**WELWYN HATFIELD BOROUGH COUNCIL
EXECUTIVE DIRECTOR - PLANNING, PUBLIC PROTECTION AND GOVERNANCE**

DELEGATED APPLICATION

Application No: 6/2021/2713/HOUSE
Location: 99 The Ridgeway Cuffley Potters Bar EN6 4BG
Proposal: Erection of a two storey side extension with two front and two rear dormer windows
Officer: Ms Kirsty Shirley

Recommendation: Refused

PROJECT: Proposed extension and alterations DRAWING NUMBER: 21023/5F

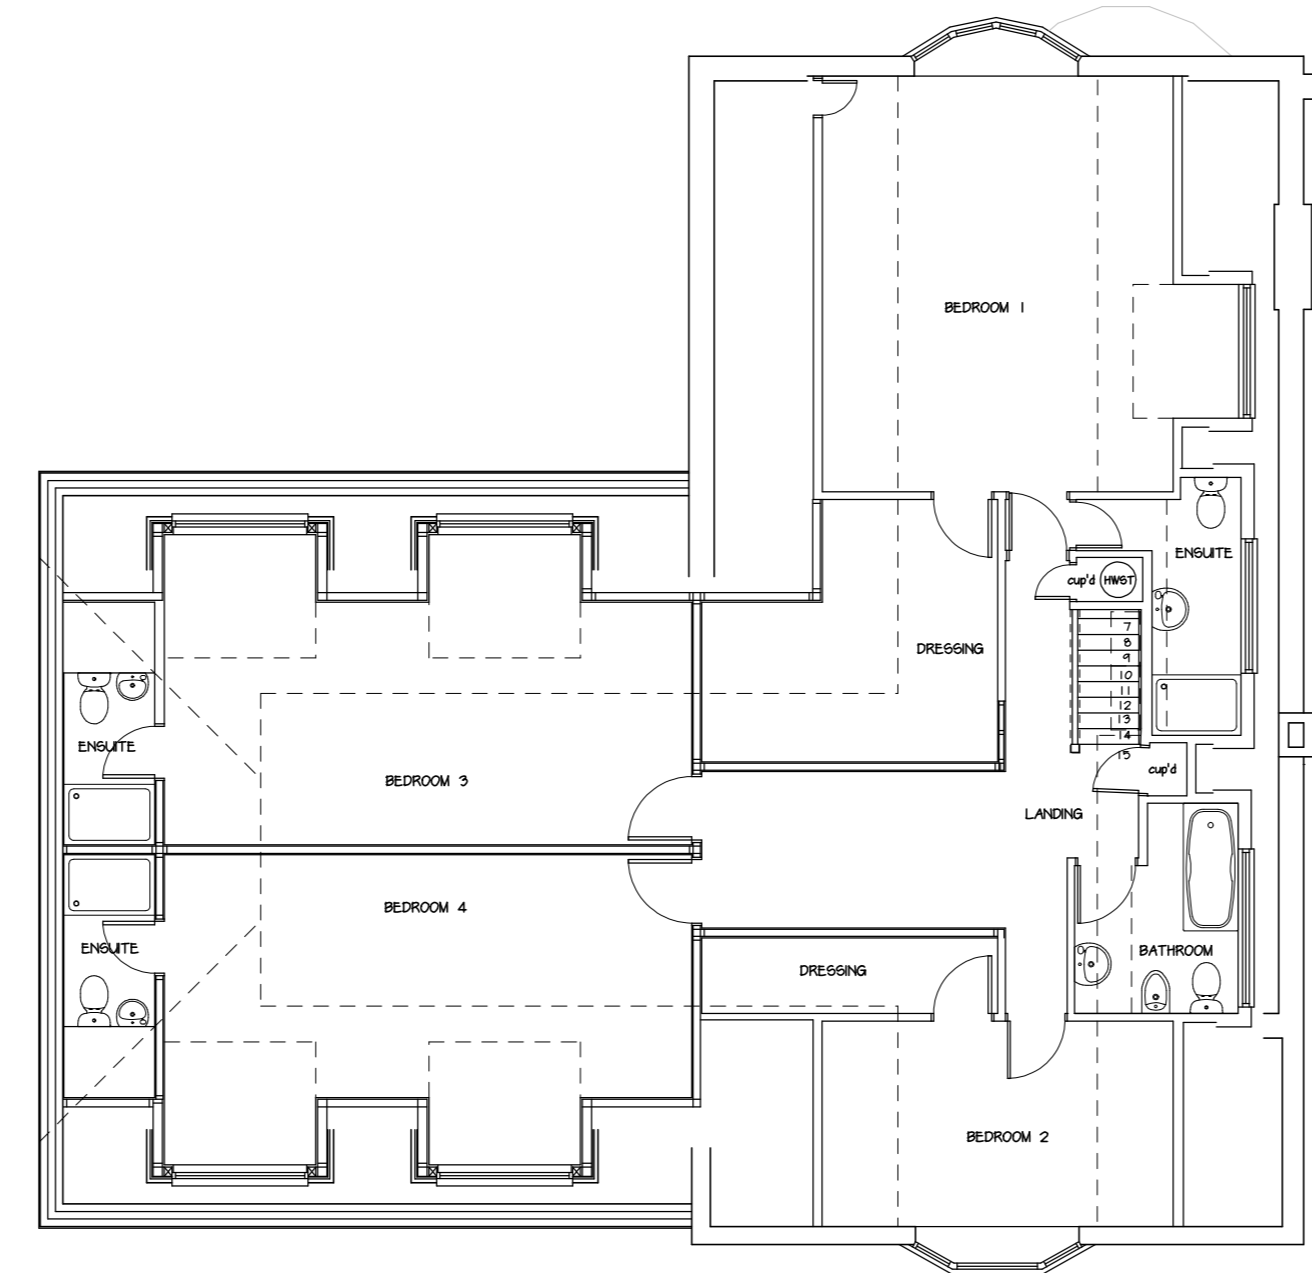
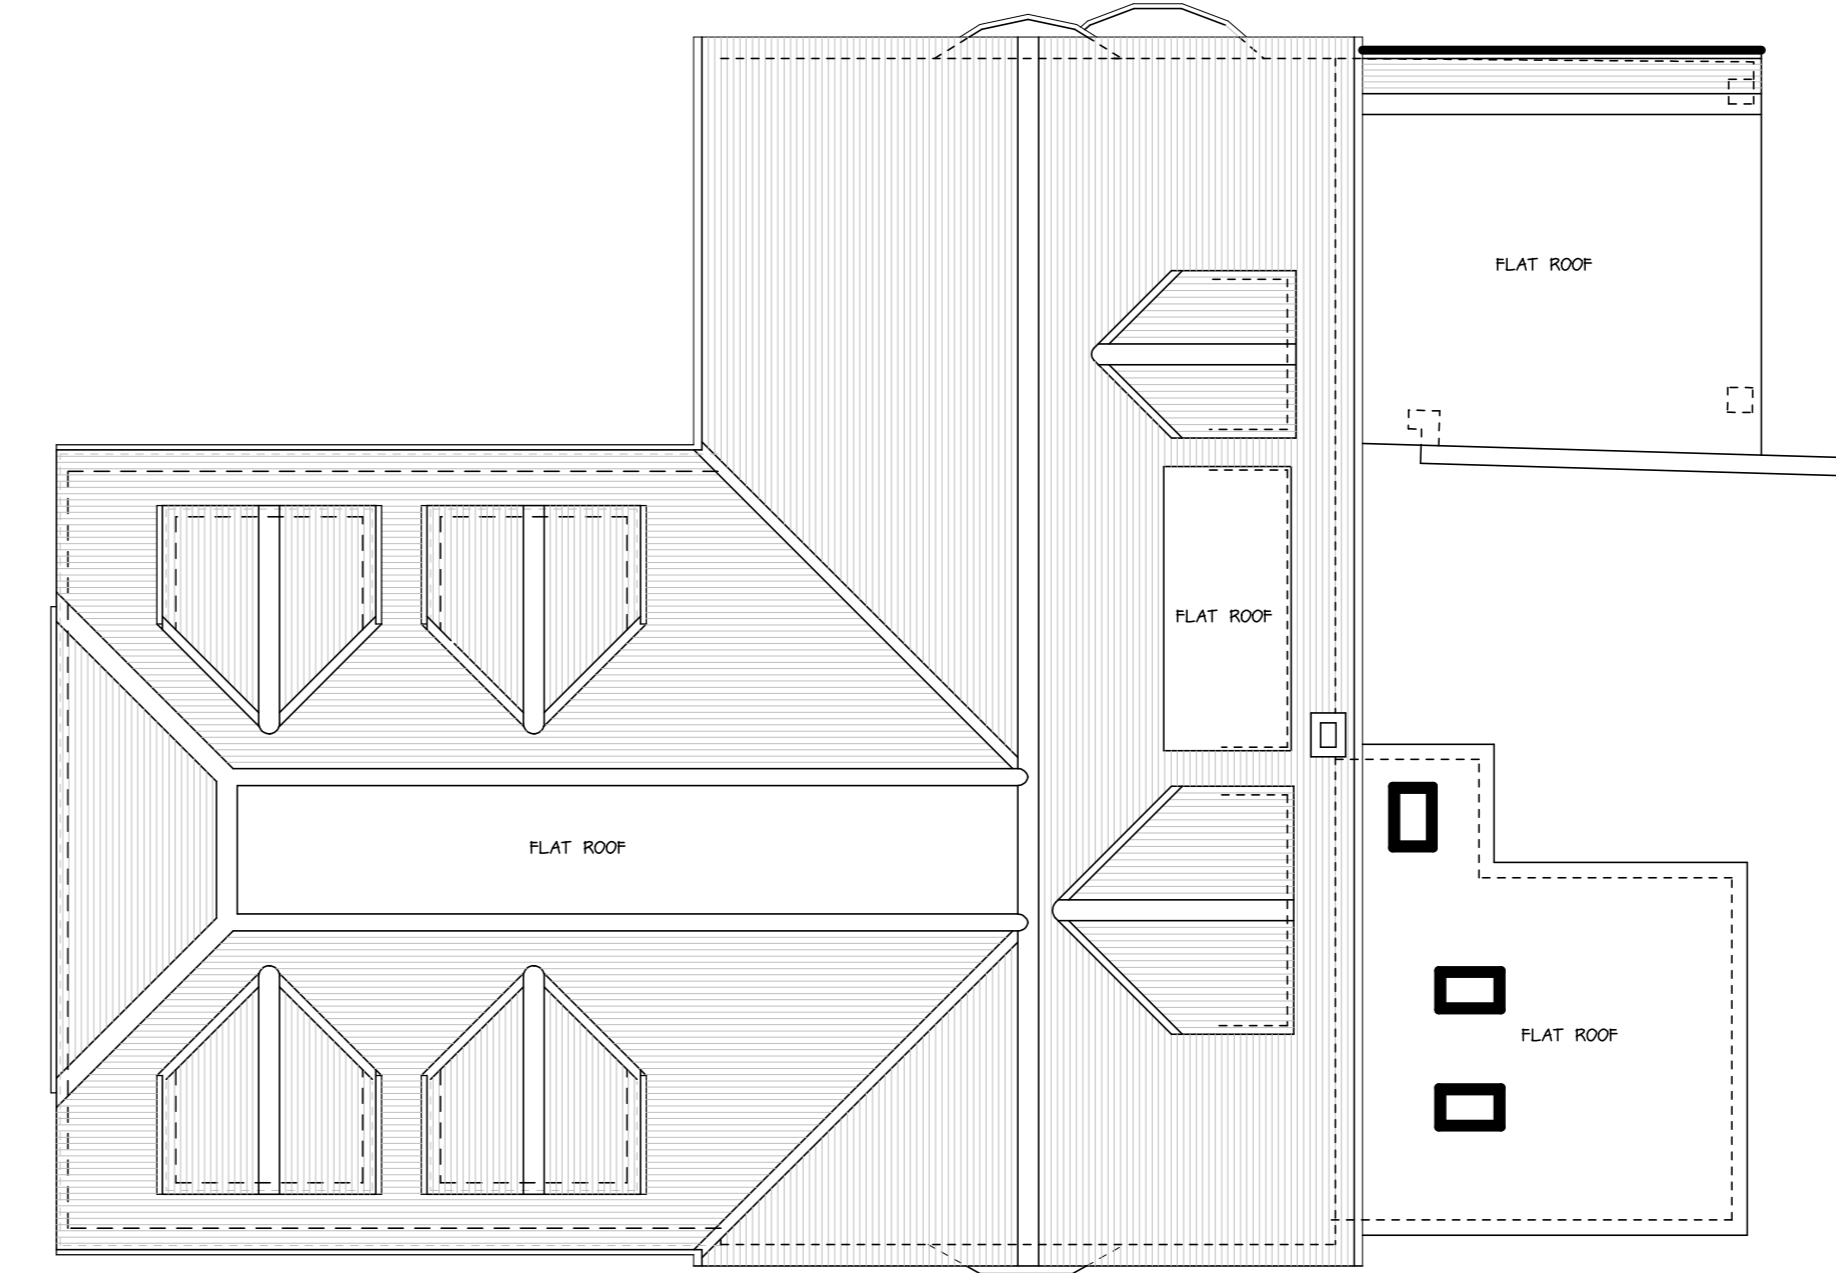
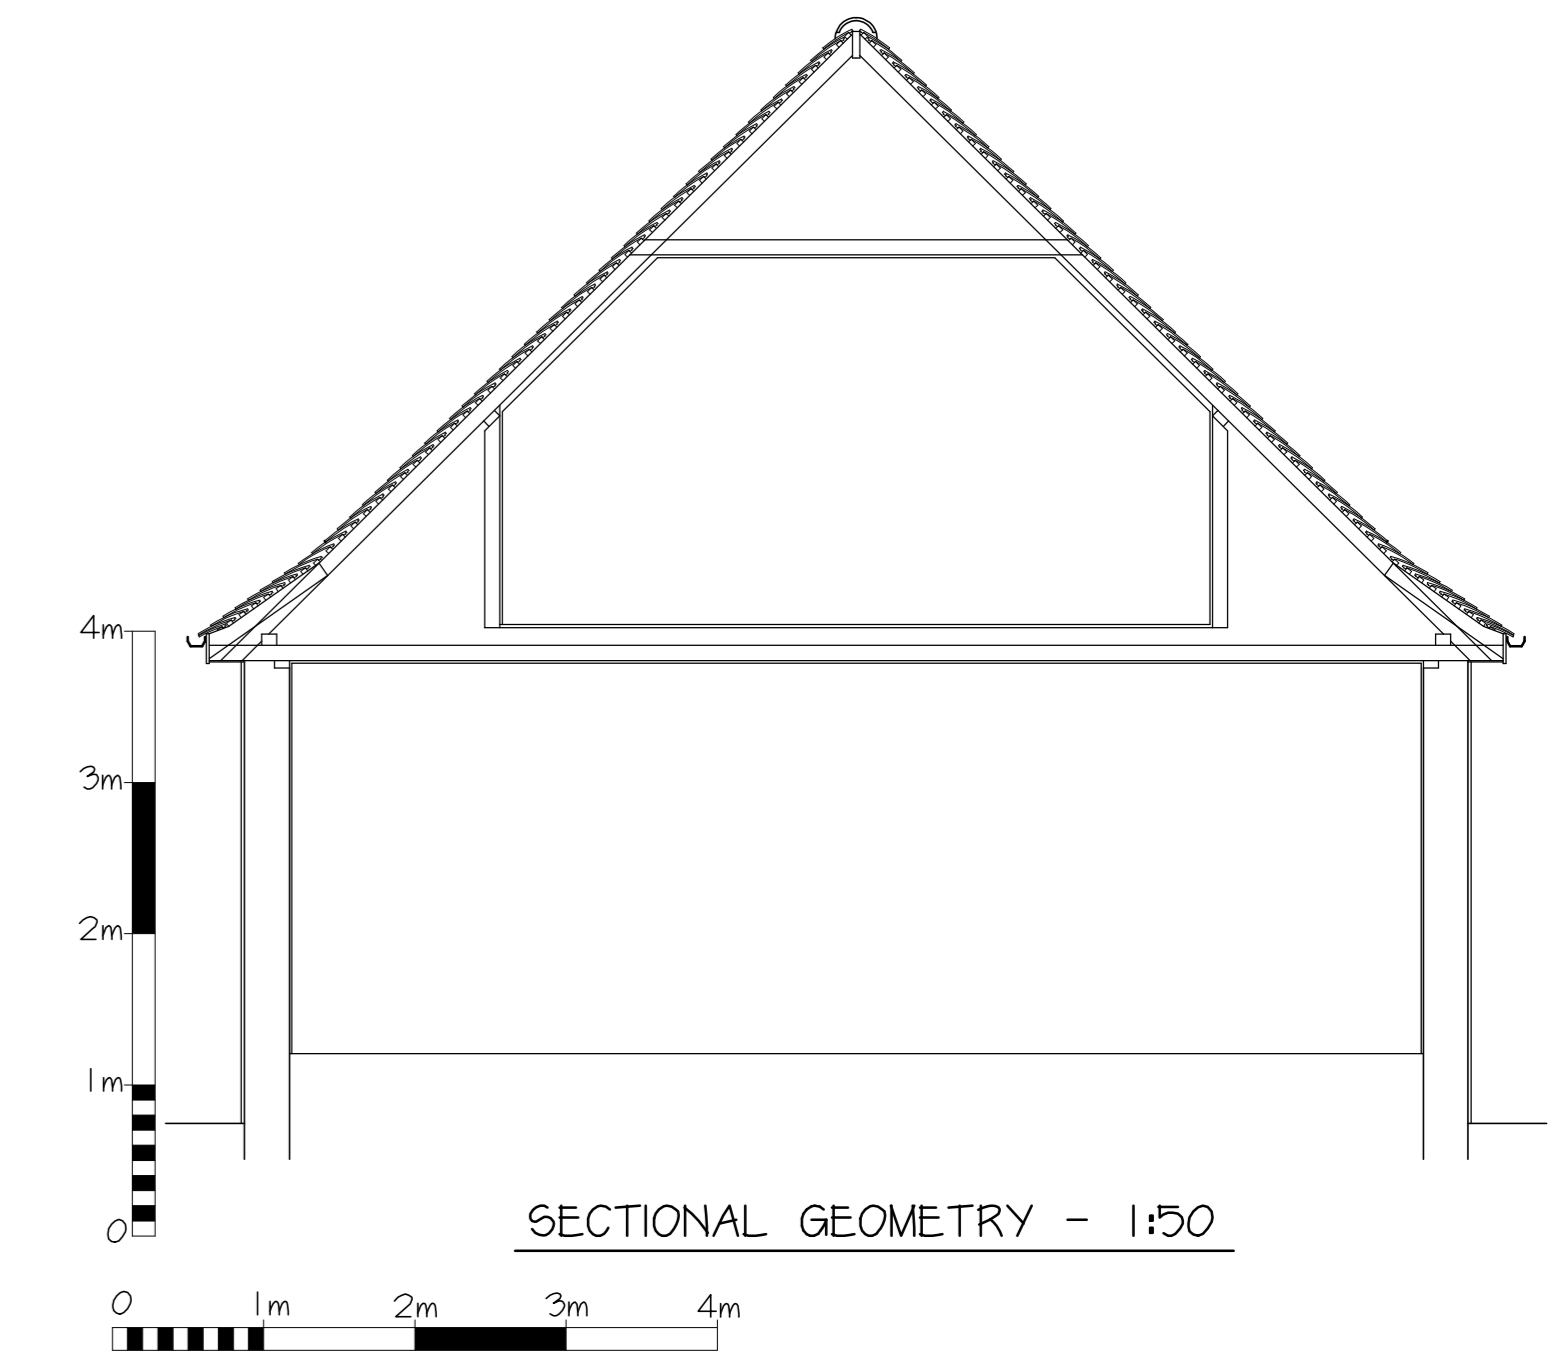
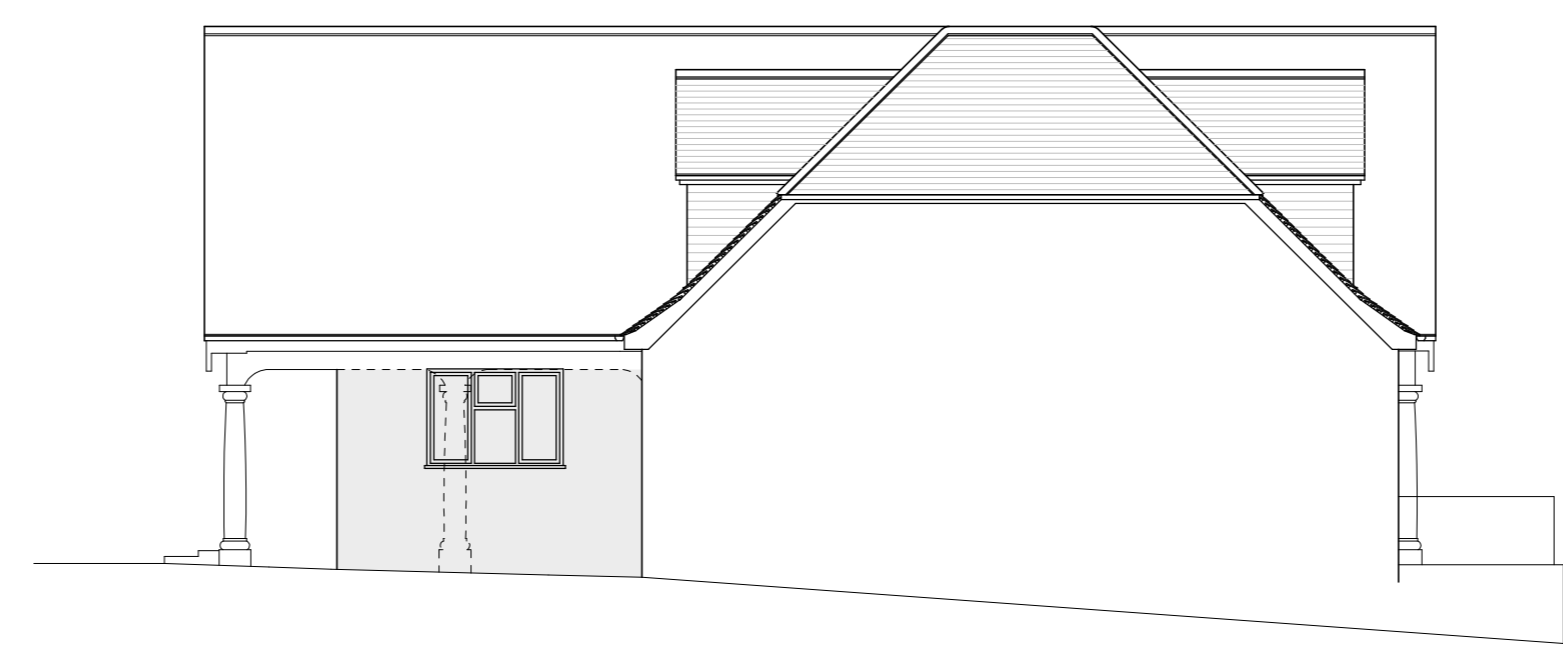
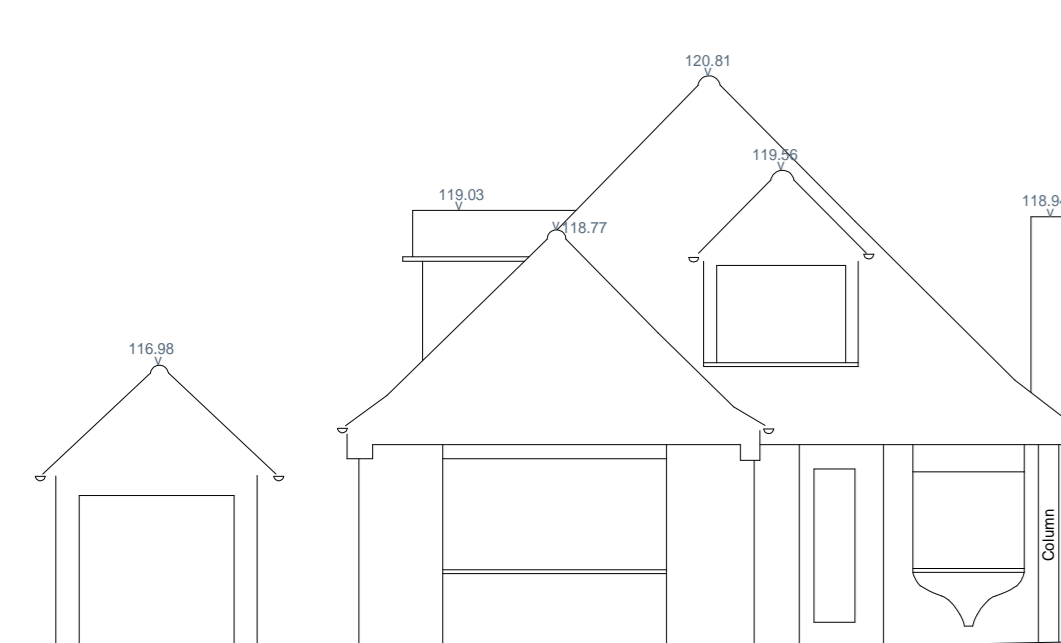
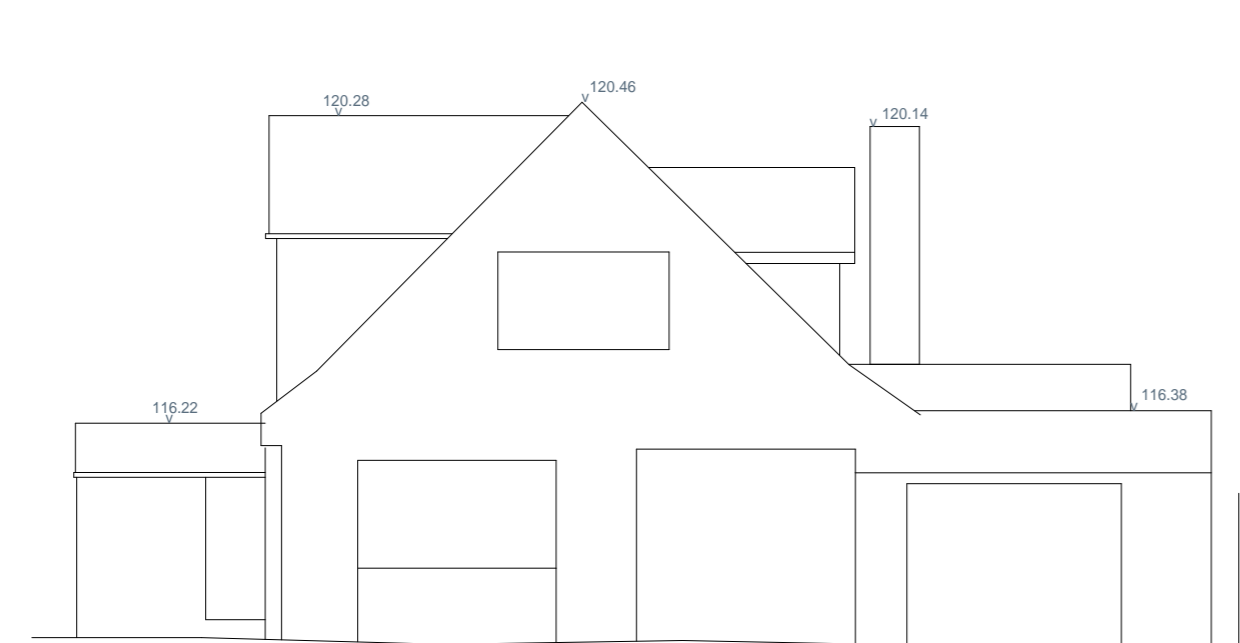
The dwelling has been significantly extended before. The planning history shows that the footprint of the original dwelling was approximately 107m², with original the floor space approximately 174m². The existing footprint of the dwelling is approximately 251m² and the existing floor space approximately 338m². The proposal would increase the footprint of the dwelling to approximately 266m², and floor space to approximately 423m². The proposal therefore represents an approximate increase in footprint of 148%, with an increase in floor space approximately 143%. The dwelling has already been extended beyond what could reasonably be considered proportionate in numerical terms and the proposal would add considerable additional floor space.

In terms of a qualitative assessment, the proposed extension would add substantially to the scale and bulk of the dwelling, particularly at first floor and roof level. The existing dwelling is a modest gable fronted bungalow with a ridge running front to back. The proposal would introduce a second ridge extending to the side in an 'L' configuration. This would result in substantial additional bulk, particularly at roof level where two front and two rear facing dormers are also proposed. The extended roof would also feature a half hip to the side with eaves higher than the host dwelling.

It is considered that the cumulative impact of the existing additions and the proposed extension would be that substantial in comparison to the original building as to be disproportionate. The proposal therefore represents inappropriate development within the Green Belt. The NPPF confirms that inappropriate development is by definition harmful to the Green Belt.

The subject dwelling forms part of a ribbon of detached dwellings of various sizes on the southern side of The Ridgeway. There are gaps between and over buildings which enable views to the expansive countryside beyond. The proposal would be visible from the road and footpath to the front of the site and potentially from more distant vantage points in the wider countryside. The proposal would demonstrably increase the size of the building. Accordingly, it would introduce built form in an area which currently provides open space. The proposal would therefore reduce the openness of the Green Belt.

The proposal would add further development to an already disproportionately extended dwelling. When considered cumulatively, the proposal would result in

<p>disproportionate additions over and above the size of the original building in terms of bulk, scale and massing. The visual prominence of the dwelling would also significantly increase and the space around the dwelling would be reduced resulting in harm to the openness of the Green Belt. The essential characteristics of Green Belts are their openness and their permanence and the loss of openness in the Green Belt resulting from the proposed extensions would conflict with this essential characteristic. Significant weight must be attached to this loss of openness.</p> <p>For the reasons discussed, the proposal fails to meet the exceptions set out in paragraph 149 of the NPPF. It would, therefore, be inappropriate development in, and thus harmful to, the Green Belt. It would also conflict, with Local Plan Policy RA3 and emerging Policy SADM34, which seek, among other things, to ensure that extensions, either alone or cumulatively with other extensions, do not result in disproportionate additions over and above the size of the original dwelling. Furthermore, the increased bulk and massing of the proposed development would result in a loss of openness and visual permeability of the Green Belt.</p> <p>As a result of the above, very special Circumstances are required to outweigh the inappropriate development, as prescribed by national planning policy. This is discussed in more detail later on in this report.</p>
